From: Joyce Christie
Sent: 18 March 2022 13:51
To: Sarah Greenall
Subject: 22/00336/F 1 Meadow Crest Cottages Burdrop resubmission of 21/00565/F

1 Meadow Crest Cottages:

Current Proposal 22/00336/F:

Existing & Proposed
 Site Plans

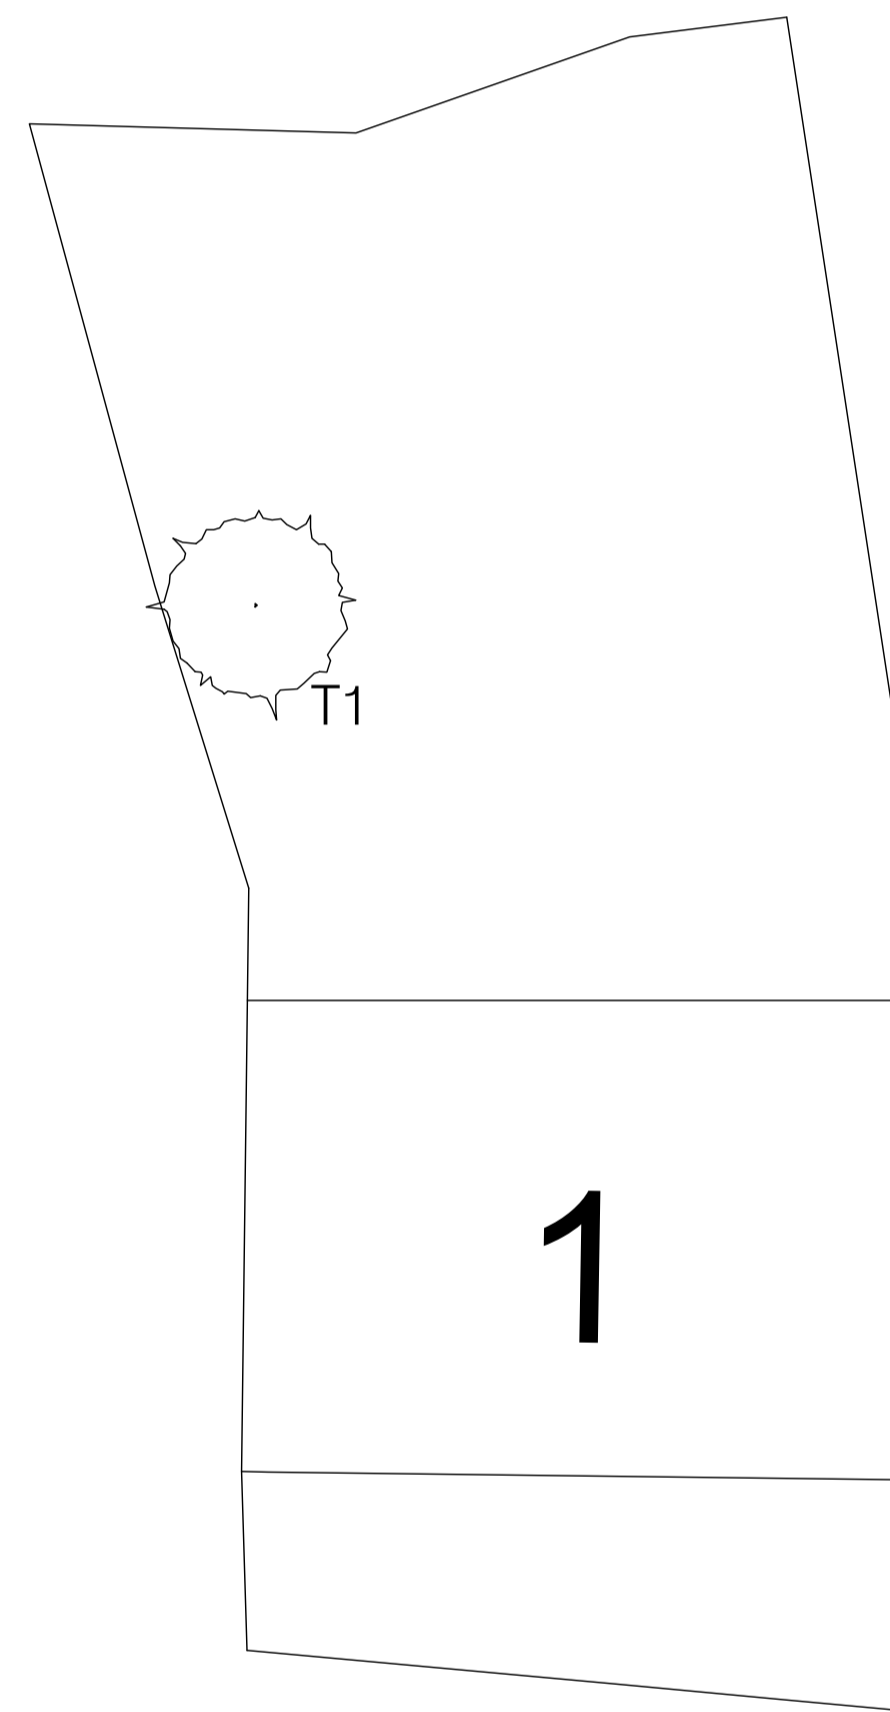
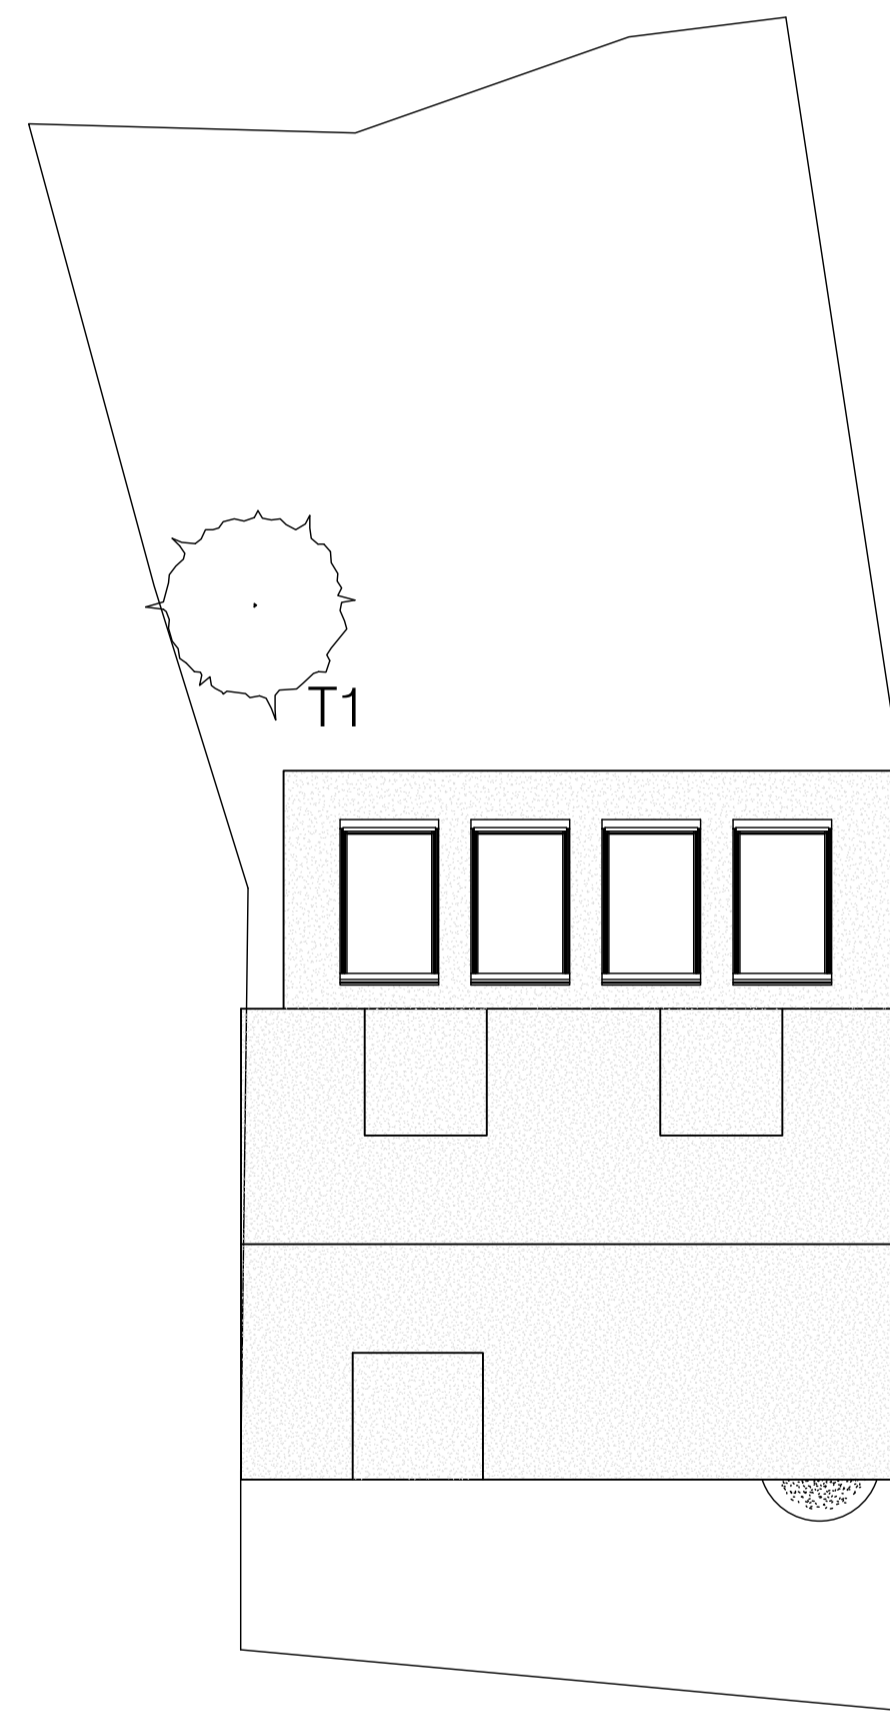
This application is for a single storey flat-roofed extension, built across almost the full width of the rear elevation, with a heavy fascia to the eaves and a large glazed screen below within a 'goal-post' of masonry. The current elevations do not show the 4No large planar rooflights that are shown on the roof plan. The west elevation of the proposed extension would align with the 1.5 storey gabled extension at No 2.

The current design would make a greater impact than the unregistered 2013 scheme as it is heavier and obscures more of the rear elevation. It is possible that the fascia could be quite dominant in southerly views of the rear elevation from the Conservation Area. The proposed extension would cause some harm to the non-designated heritage asset. There would also be some harm to the Conservation Area and the setting of Goodmays, which would be greater if the extension was approved with the heavy fascia seen on the drawings.

Whilst there is a precedent for a thatched canopy on the terrace, I have reviewed the proposal to add a new thatched canopy to the door of No1 and consider this would be difficult to detail as there is not enough wall between the door and the neighbour at No 2. This element would be impracticable and should be omitted from any application.

I would not support the extension in its current form. A single storey extension could be acceptable subject to design and detailing – see comments above. The thatched door canopy is impracticable and should be dropped.

object to a simple single-storey lean-to extension based on historic precedent if it could abut the party wall and not cause issues with the adjacent listed property. I would prefer that the did not cover the entire ground floor of the non-designated heritage asset. This could be a traditional structure but a slate roof would reduce the depth due to the required roof pitch. Alternatively it could be a modern interpretation of a lean-to, such as lightweight glass structure with a solid roof which terminates in a thin eaves. This would allow greater transparency to the rear wall of the house and reduce its impact. Omitting the 4 proposed rooflights would reduce light spill in this typically dark village. The example below shows a solid roof stopping short of the historic wall with a glazed margin allowing views of the whole wall whilst allowing natural light to be borrowed by the original rear ground floor windows. A single rooflight may be an acceptable alternative.
